Application number: 2018/93485	
What is the application for?:	Erection of detached dwelling on land adj. to no 140 Norwood Road
Address of the site or building:	140, Norwood Road, Birkby, Huddersfield, HD2 2YD
Postcode:	HD2 2JY

Type of comment: An objection

GROUND FLOOR PLAN AS PROPOSED
Scale 1.50

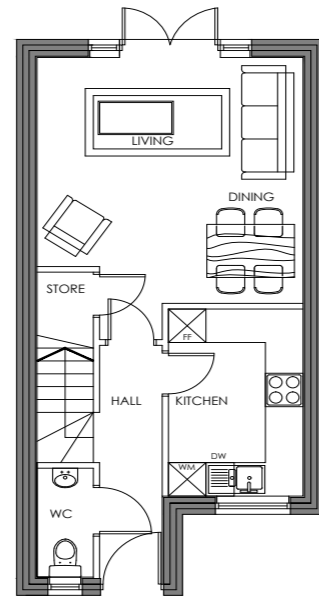
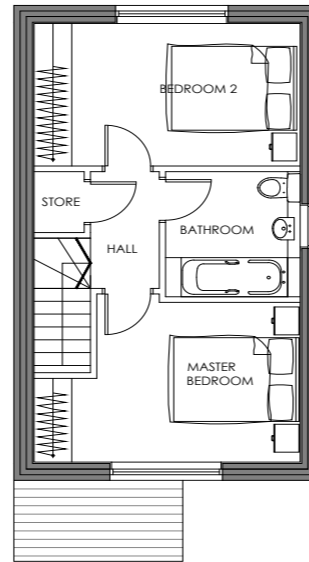
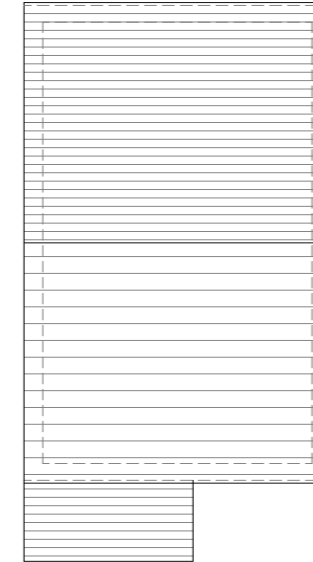
1. The proposed house is 900 millimetres away from the gable end of number 140 and is therefore taking light away from both the kitchen and first floor landing of the house.

2. The closest house to the footpath on this section of Norwood Road is 5 metres going to 9 metres in points. This suggests a building line of approximately 5 metres. The proposed house is 2.4 metres away from the footpath which is half the distance of the nearest property and therefore is out of character for the area. Based on this one third of the footprint of the proposed house is over the 5 metres.

3. The front of the proposed house is protruding 0.5 metre further forward than the other properties in the row.
4. The back of the proposed house is out of line by 0.5 metres of the rest of the row of properties.

5. The main drains for the row of properties are based within 100mm of the corner of the proposed house, therefore how do they propose to safely build the property without damaging or redirecting the main services of which they have not stated how they intend to achieve this within the application.

7. The two suggested parking bays will require the remaining established trees to also be removed from the area.
8. There has not been an application made to highways in order to drop the kerb of where the suggested parking bays are, which will require 2 parts of the footpath to be dropped.

9. The suggested visitor parking bay will be blocking the line of sight down the road to allow neighbour's to safely pull off their driveways onto Norwood Road which is already an extremely busy road, therefore creates a safety risk.

FRONT ELEVATION AS PROPOSED
Scale 1.50

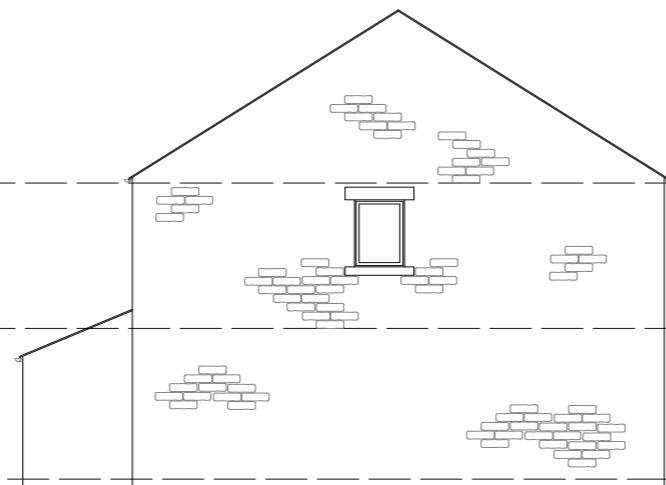
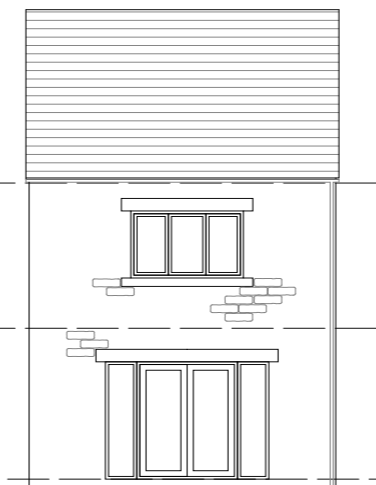
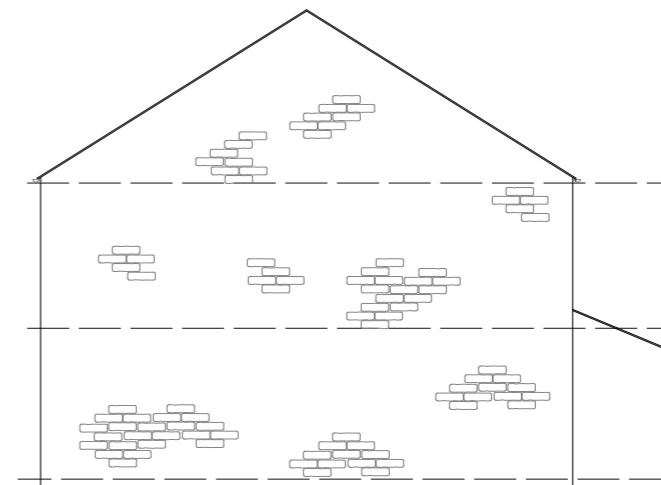
10. Property 140 has a boiler flue within the gable end which comes out directly onto the gable end of the suggested property.
11. The proposed house will obstruct the main phone line to number 140.
